3/17/26

I-5719B_U5800_Submittal S-008-4B Plans
MI-Engineering- Hydraulics Review

PROJECT REFERENCE NO. L-5719B / U-5800	SHEET NO. 10
RW SHEET NO.	
ROADWAY DESIGN ENGINEER	HYDRAULICS ENGINEER
DOCUMENT NOT CONSIDERED FINAL UNLESS ALL SIGNATURES COMPLETED	
HDR Engineering, Inc. of the Carolinas 555 Fayetteville St, Suite 900 Raleigh, N.C. 27601 N.C.B.E.L.S. License Number: F-0116

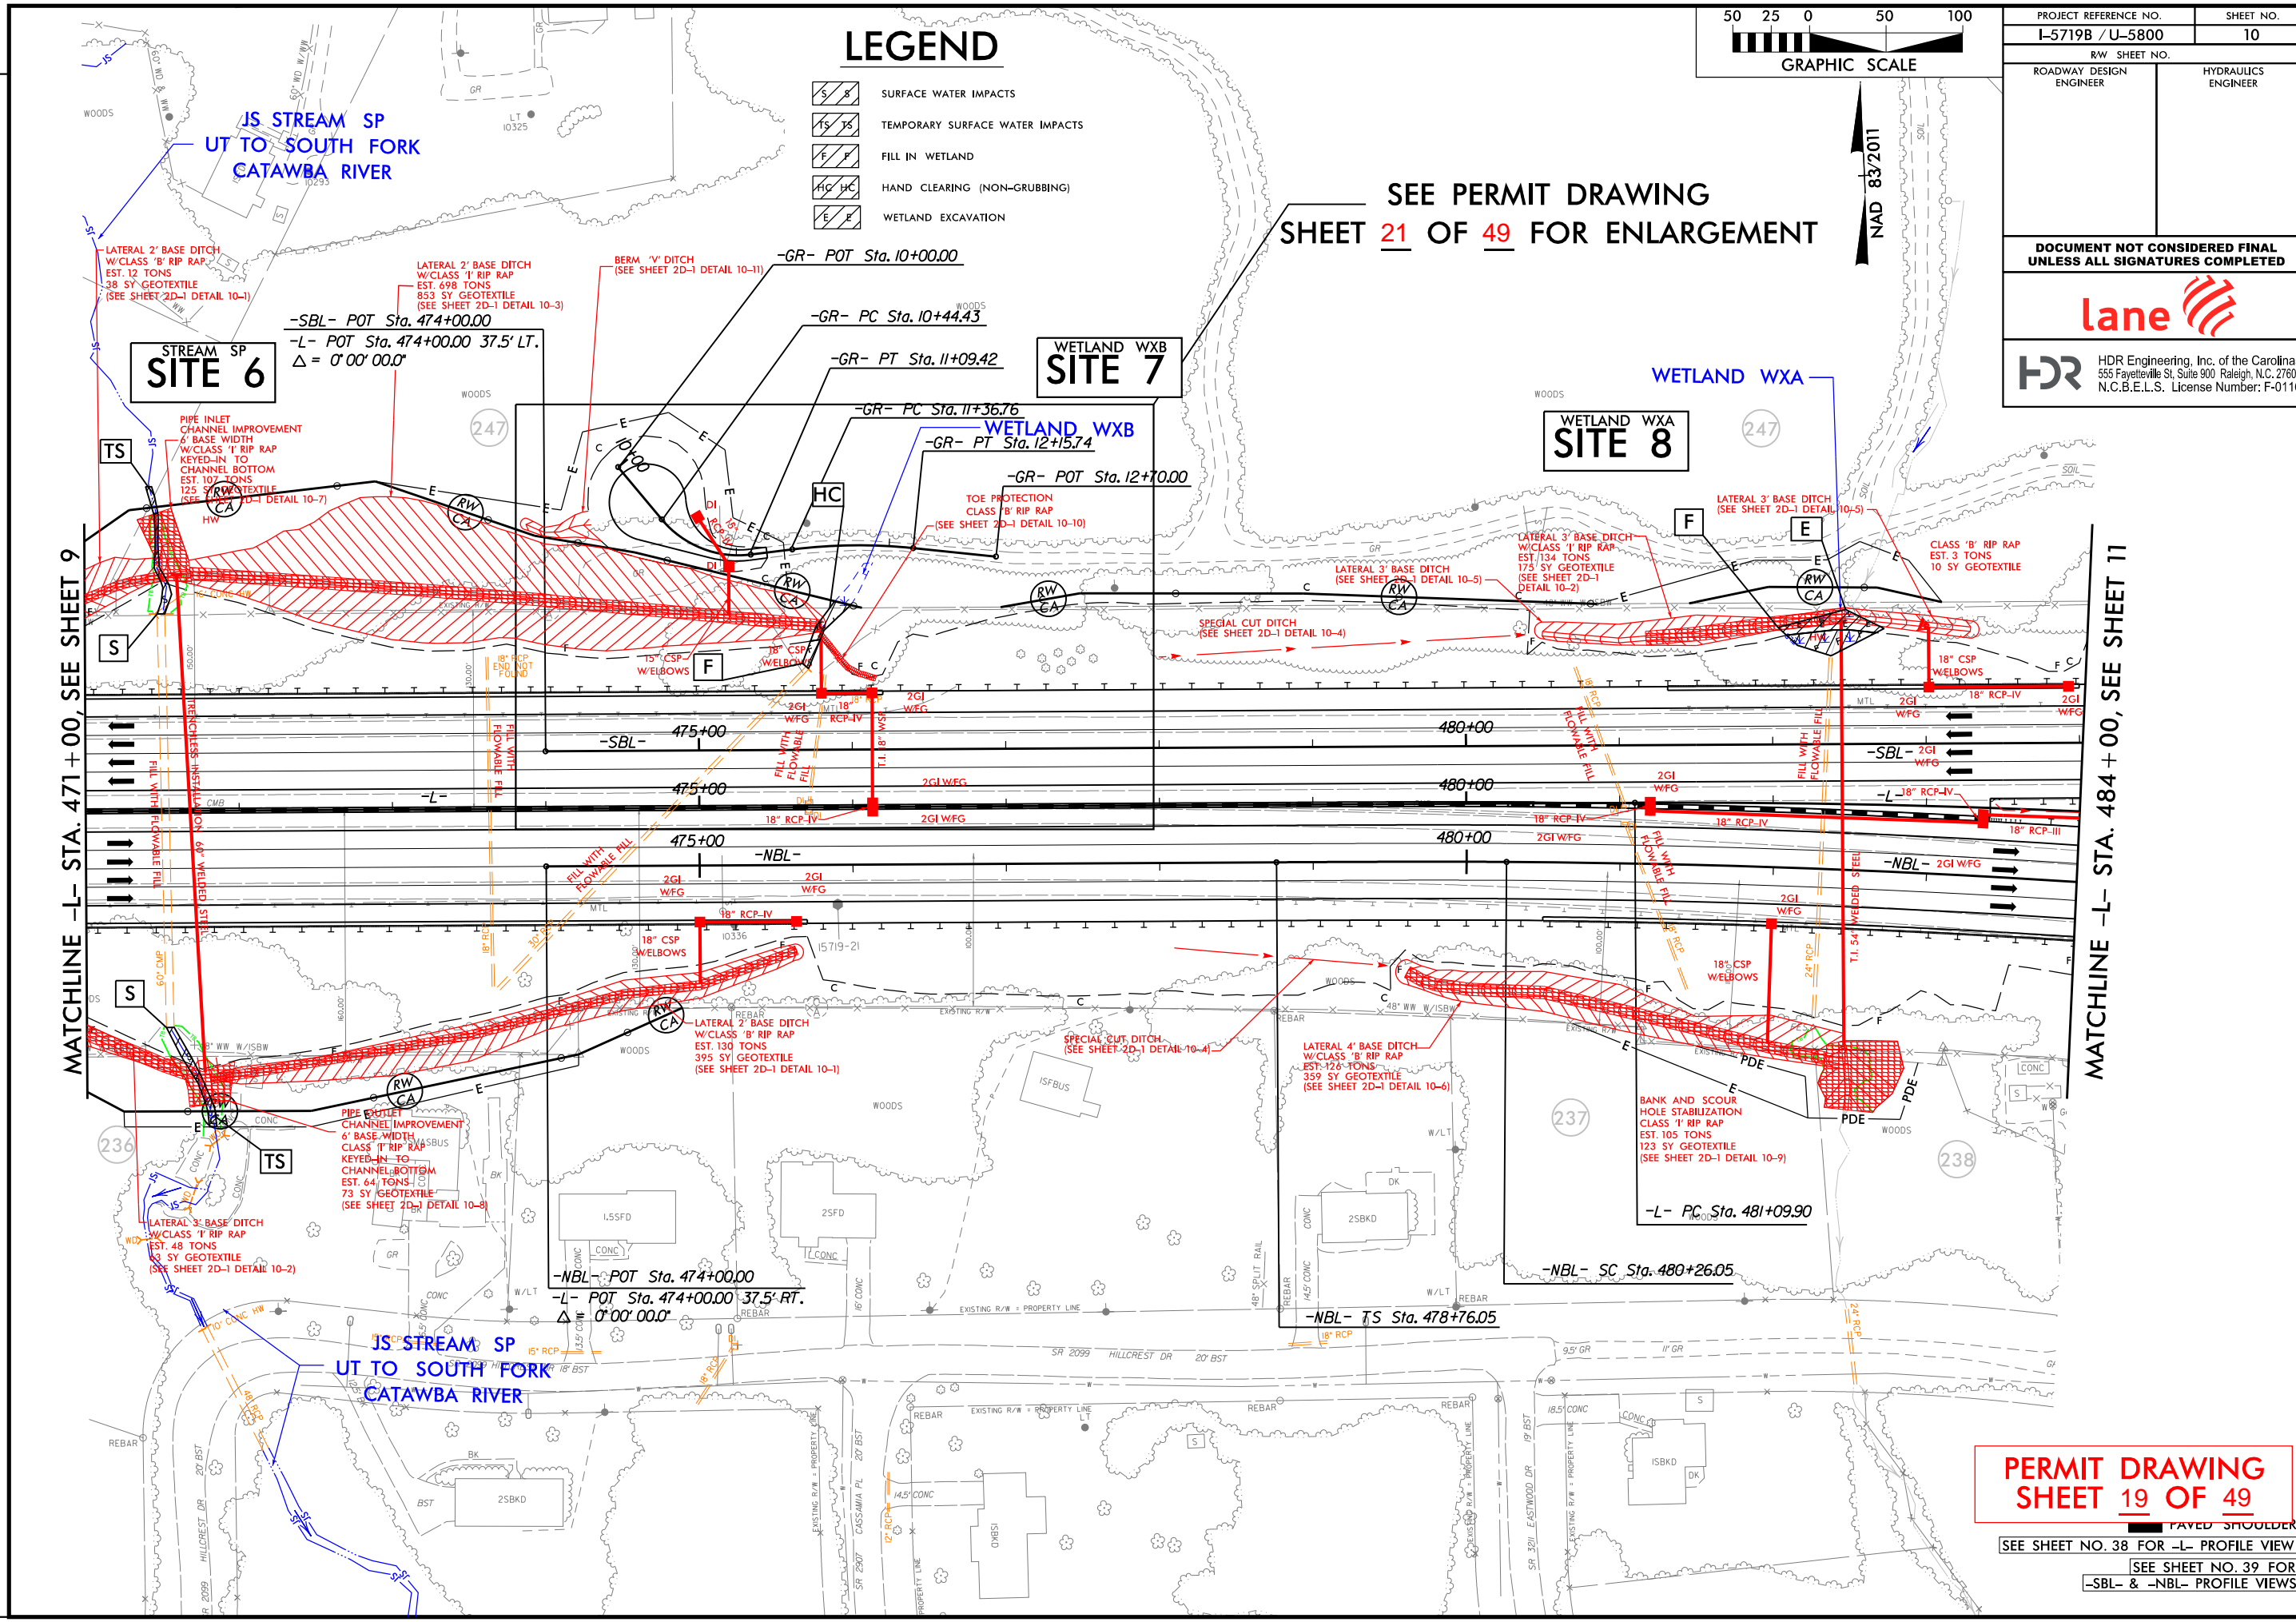
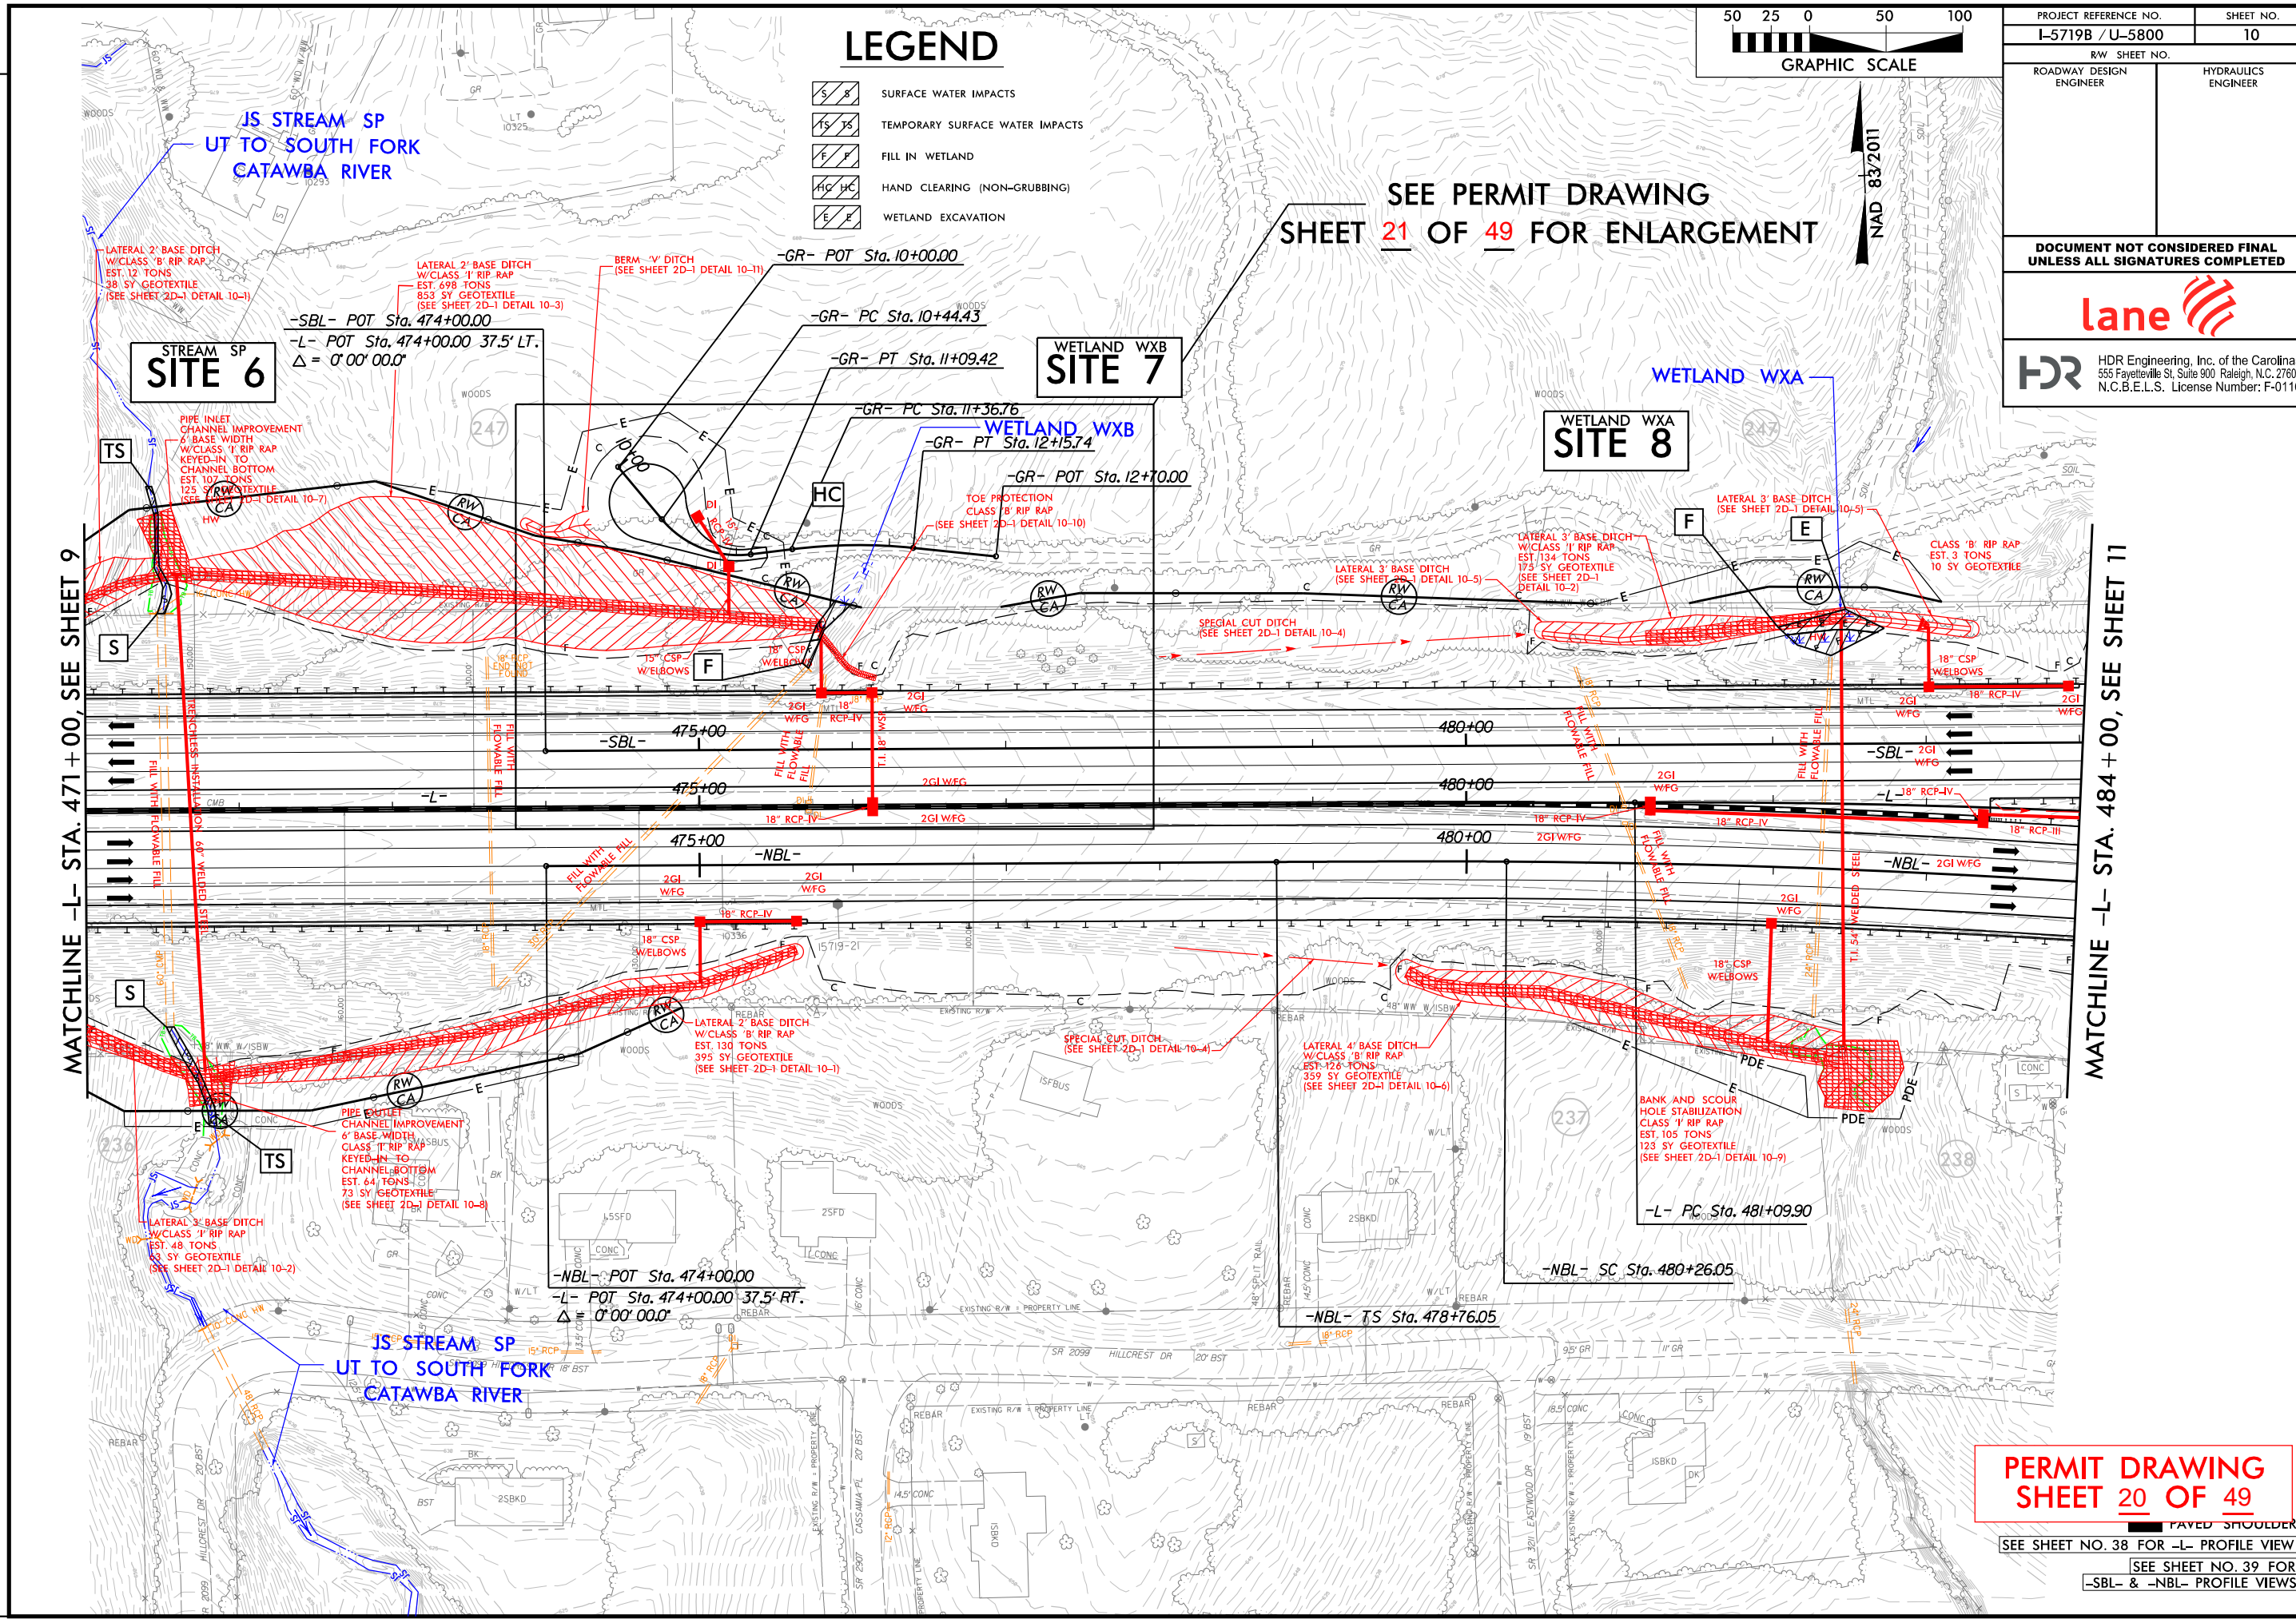
- 72" pipe at station 471+68 -L-. Are sills proposed for this pipe?
 - Discussion for meeting.
